RE: FOUR POINTS BY SHERATON HOTEL SSD-4972 – SECTION 96 MODIFICATION 2 EXPANSION, 161 SUSSEX STREET, SYDNEY

The Heritage Division of the Office of Environment and Heritage is replying to your request for comments on the proposed modifications to the above application.

Drawing Title	
SLIP STREET DETAIL EAST ELEVATION	
Drawing Number	REV.
A-DA-0305	F
Scale	
1:200 @ A0

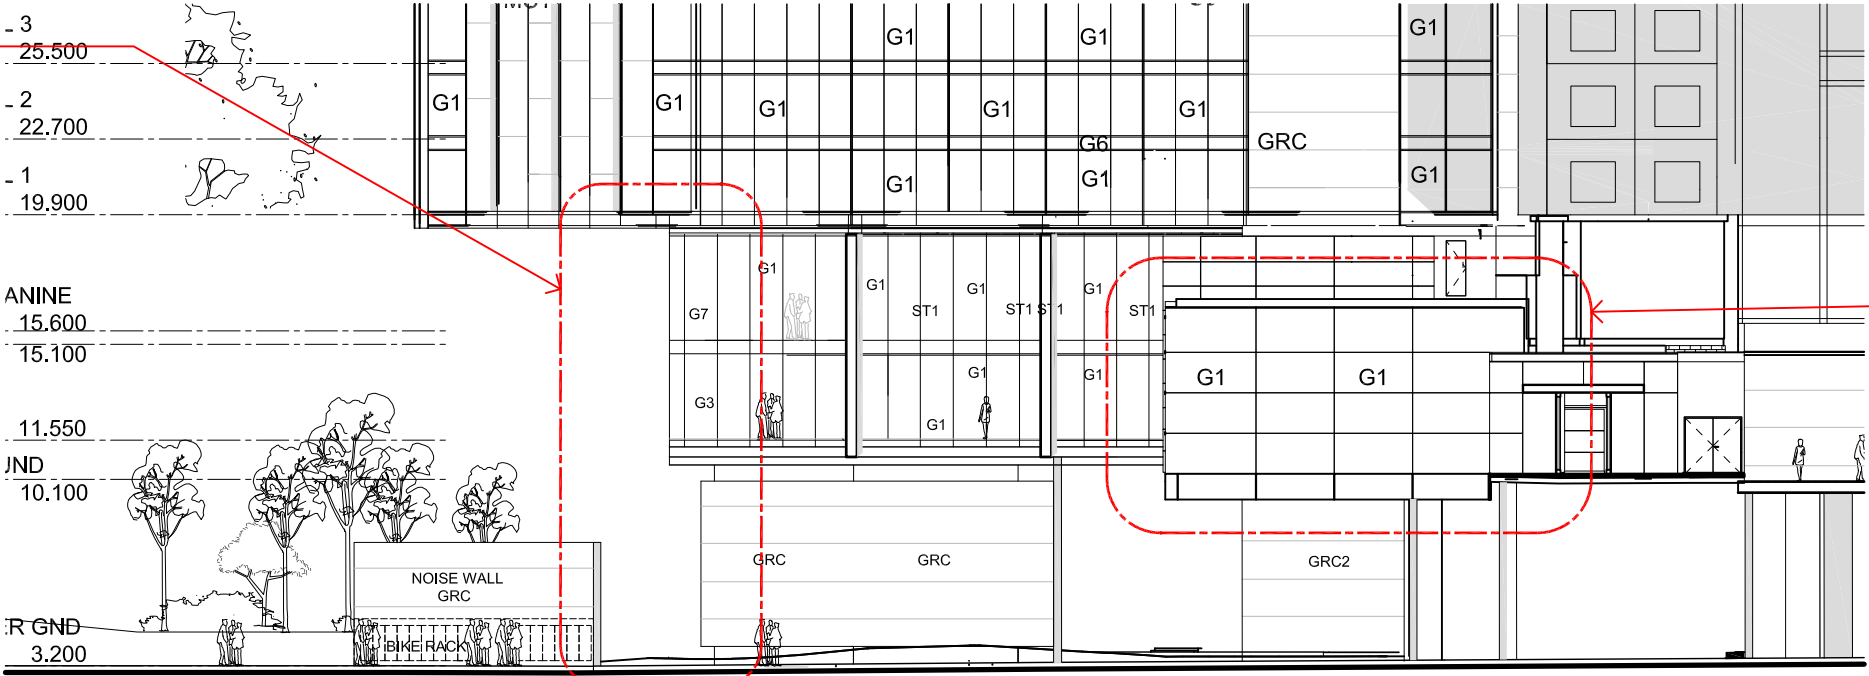
The trees that are currently located between the proposed new building and Corn Exchange are likely to provide a degree of screening of the new building from the State Heritage Registered Corn Exchange building. No assessment of the heritage significance of these trees has been undertaken and therefore it is impossible for any meaningful comments on potential heritage impacts to be provided. Generally, the aim should be to retain these trees to assist in screening the existing building from the proposed.

Drawing Title
NORTH & SOUTH ELEVATION
Drawing Number
A-D4-0301
REV: K
Scale
1:200 @ A0

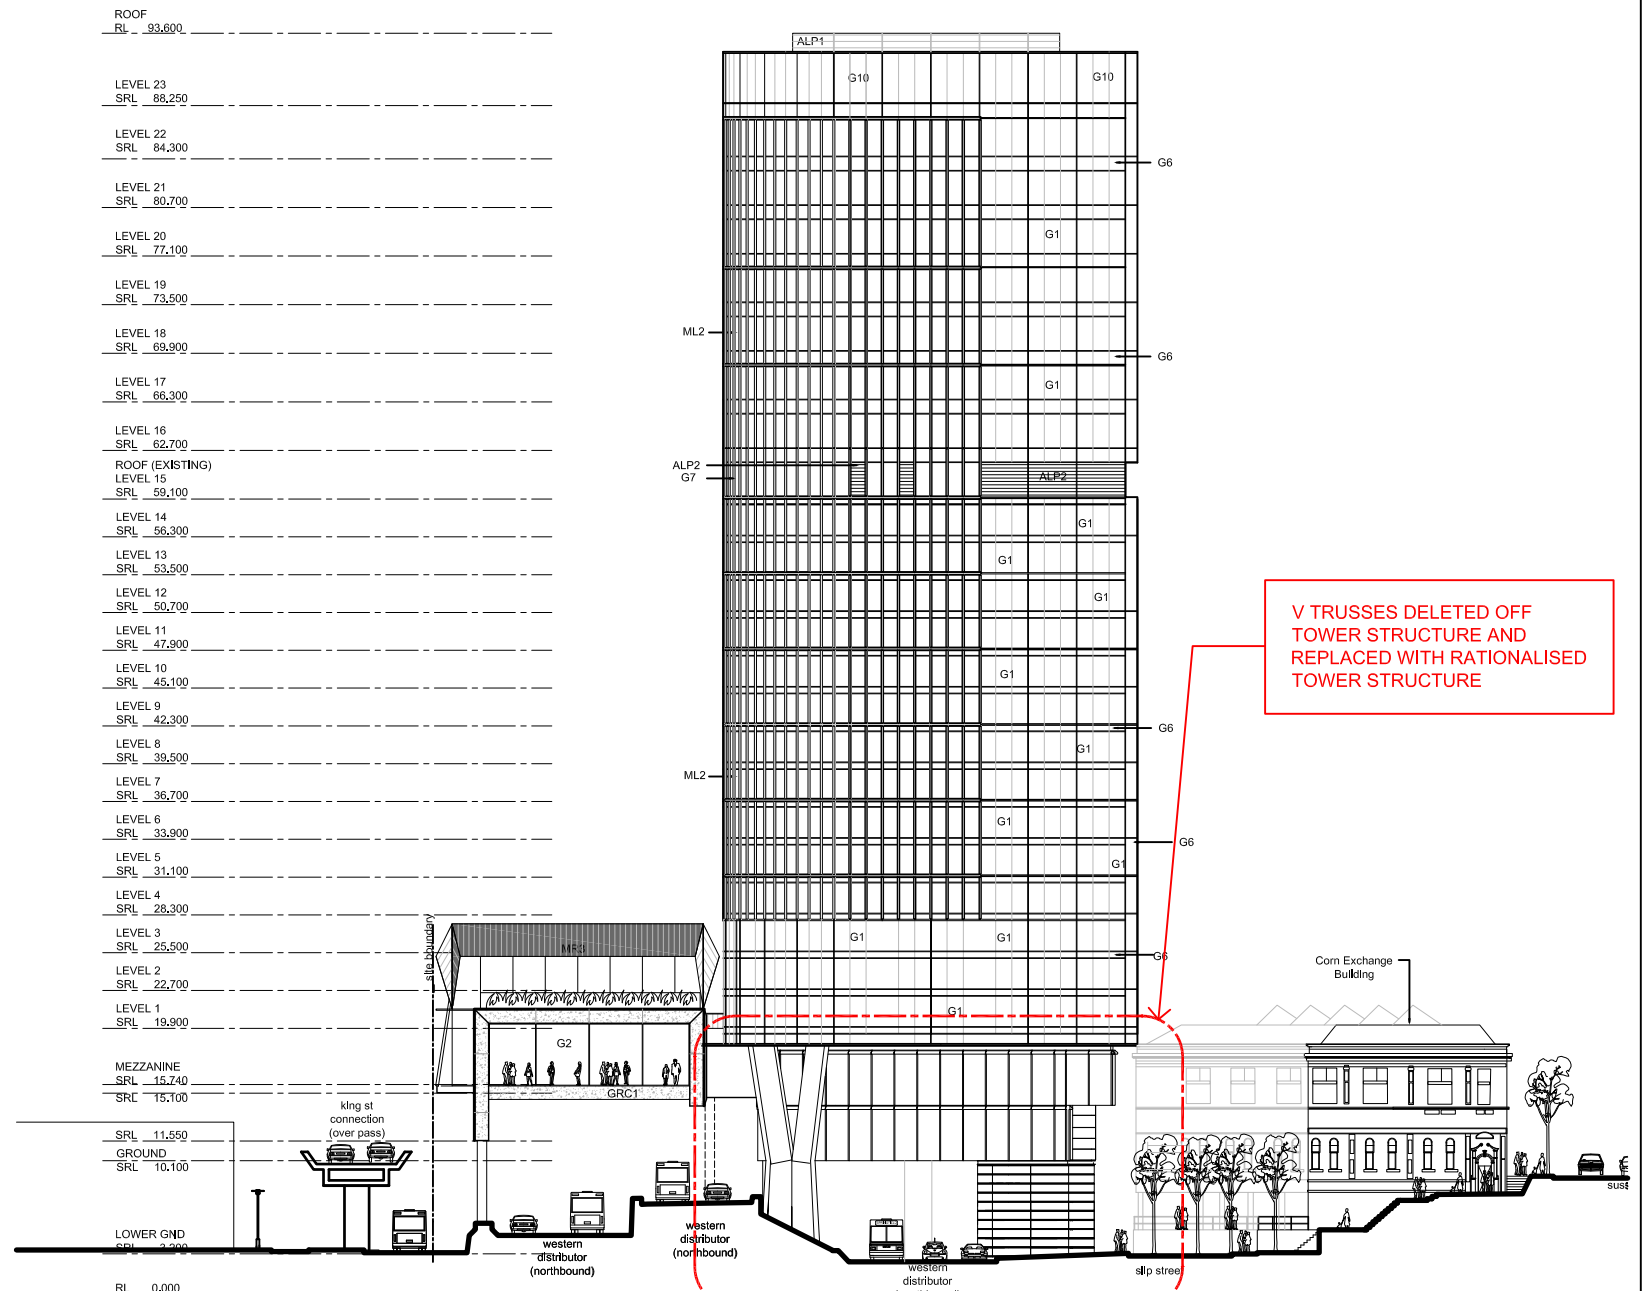
The modification to the configuration of the structural columns and increase in number of structural columns from 3 to 8 is likely to have acceptable heritage impacts. Any additional excavations must be undertaken in accordance with previously approved archaeological conditions.
